Rampion Two Offshore Wind Farm

Appendix N6 to Natural England Deadline 6 Submission

Planning Inspectorate Reference EN010117

01 August 2024

Company: GOBE	Drawn By: SWM	Chk/Prvd: NH	Drawn Date: 04/08/2023	Status: FINAL
------------------	------------------	-----------------	---------------------------	------------------

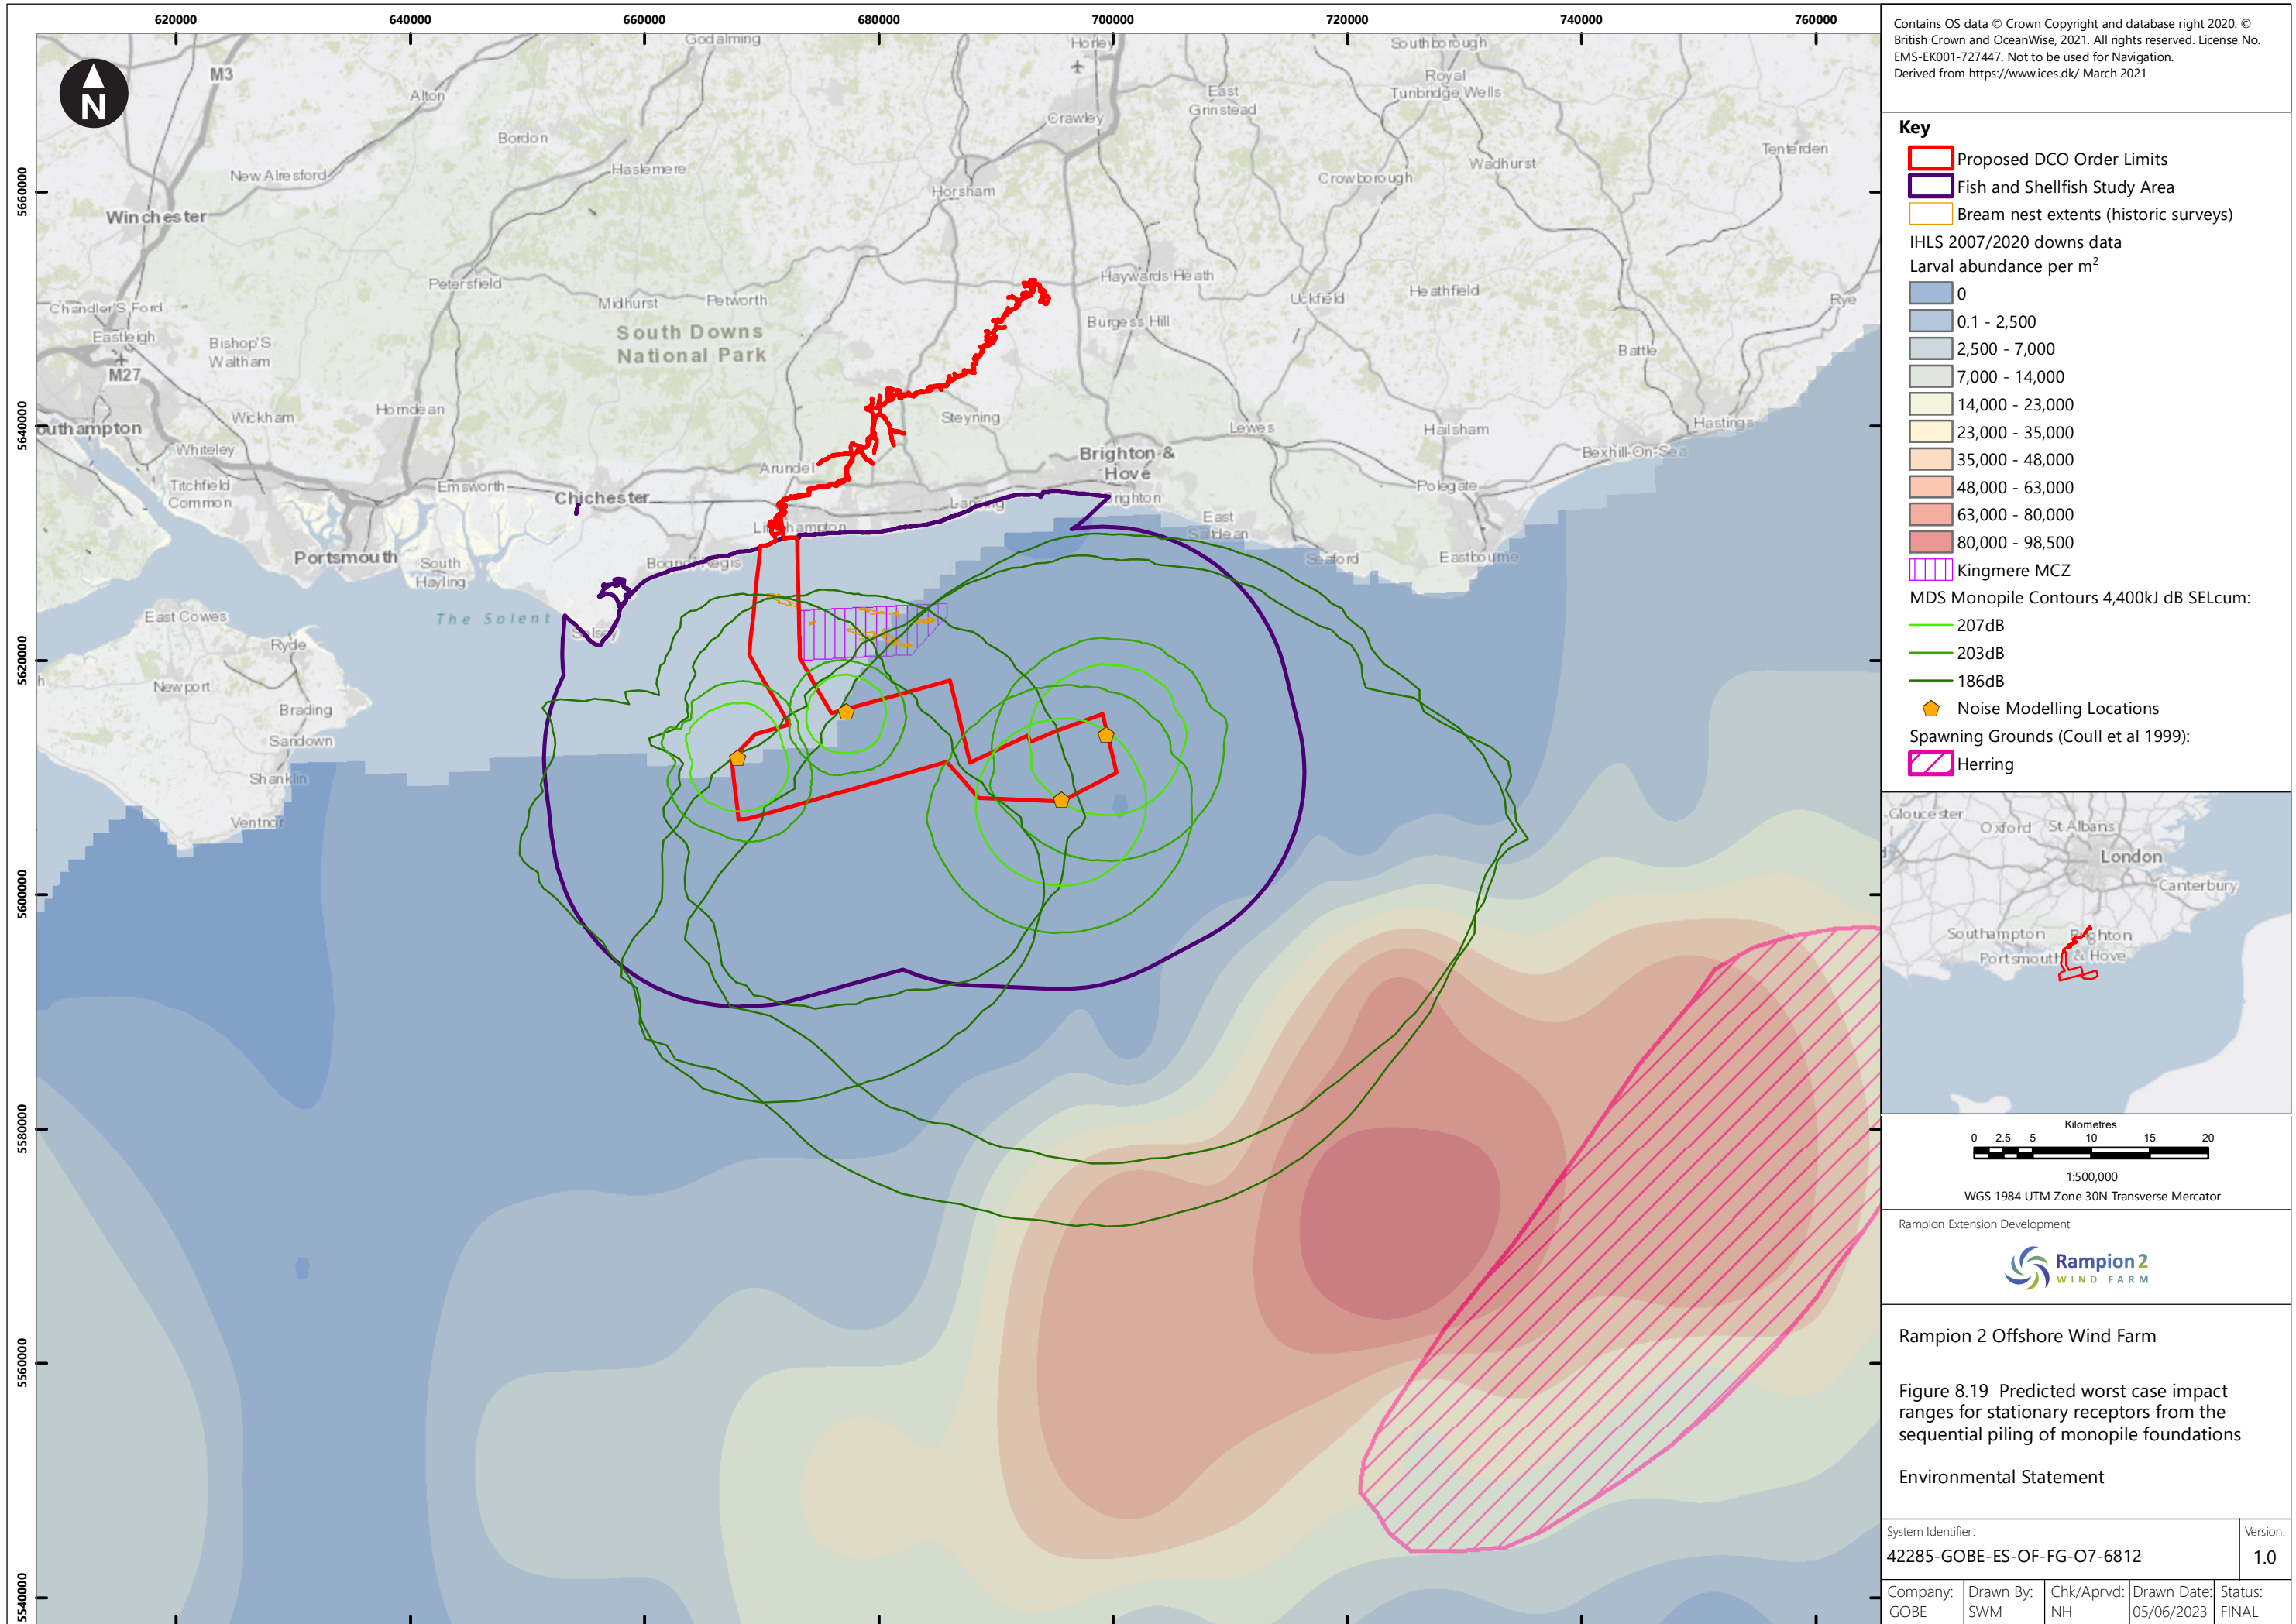
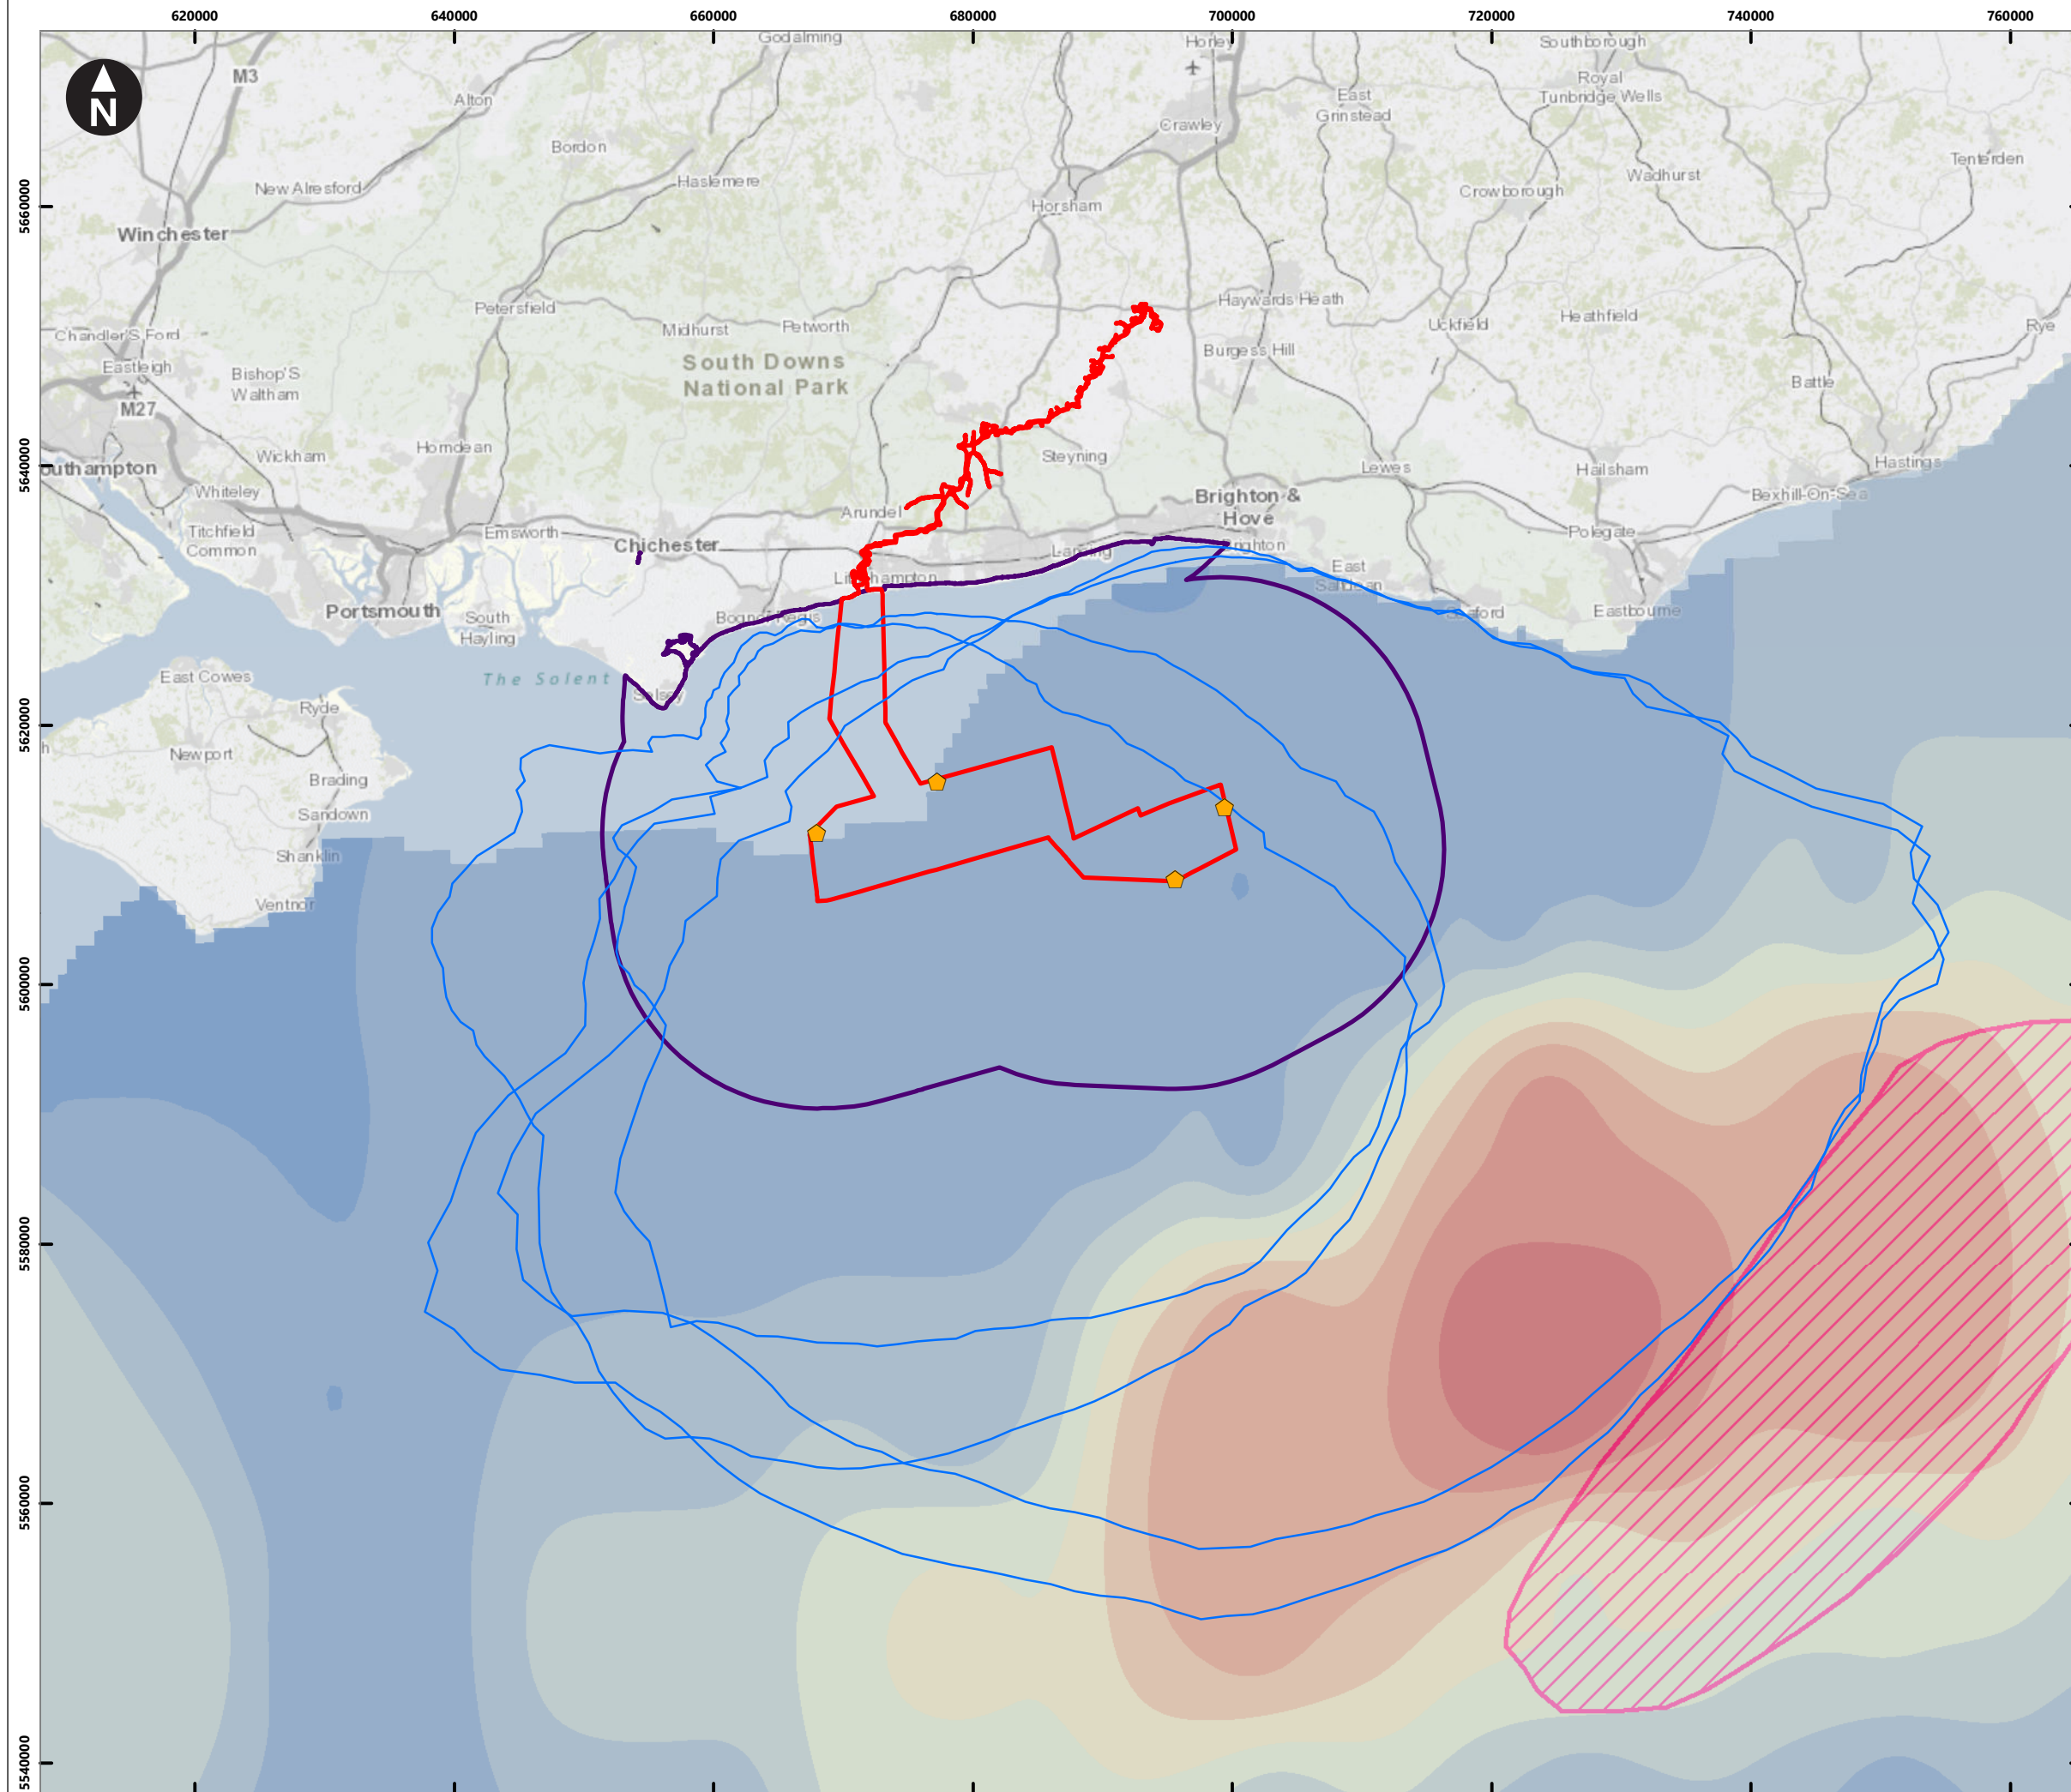
FS 3.1	<p><i>Worst Case Scenario – Piling Noise for Fish and Shellfish</i></p> <p>The Applicant Natural England</p>	<p>The ExA notes that Natural England has remaining concerns/questions with regards to the modelling of underwater noise and the worst-case scenarios for different situations [REP5-139,Page 2]. It states:</p>	<p>Natural England provided detailed comments on our position regarding fish and shellfish at Deadline 5. Where appropriate we have updated this position based on further information provided at Deadline 5 and provided directly by the Applicant on the 26/07/2024. Natural England have provided</p>

<p><i>“We advise that a clear explanation of whether sequential or simultaneous piling has been modelled as the worst case in each situation still needs to be provided and each figure needs to be clearly labelled with which scenario it is demonstrating. Additionally, as raised in our Relevant Representations (Appendix E, Point 27), where piling is conducted simultaneously at two locations we question what the closest distance between locations is likely to be, and how this is considered in terms of impacts on the MCZ’s.”</i></p> <p>The ExA also acknowledge that the Applicant has responded on these matters raised by NE, such as the response to Point E27 at Deadline 1 [REP1-017], for example</p> <p>The ExA requests the Applicant and Natural England resolve these issues before the close of the Examination. If the parties are unable to resolve these matters, provide a joint Position Statement and the options available to the Secretary of State.</p>	<p>updated advice in Appendix E6 of this submission on this point.</p> <p>Natural England has not seen a position statement from the Applicant.</p>
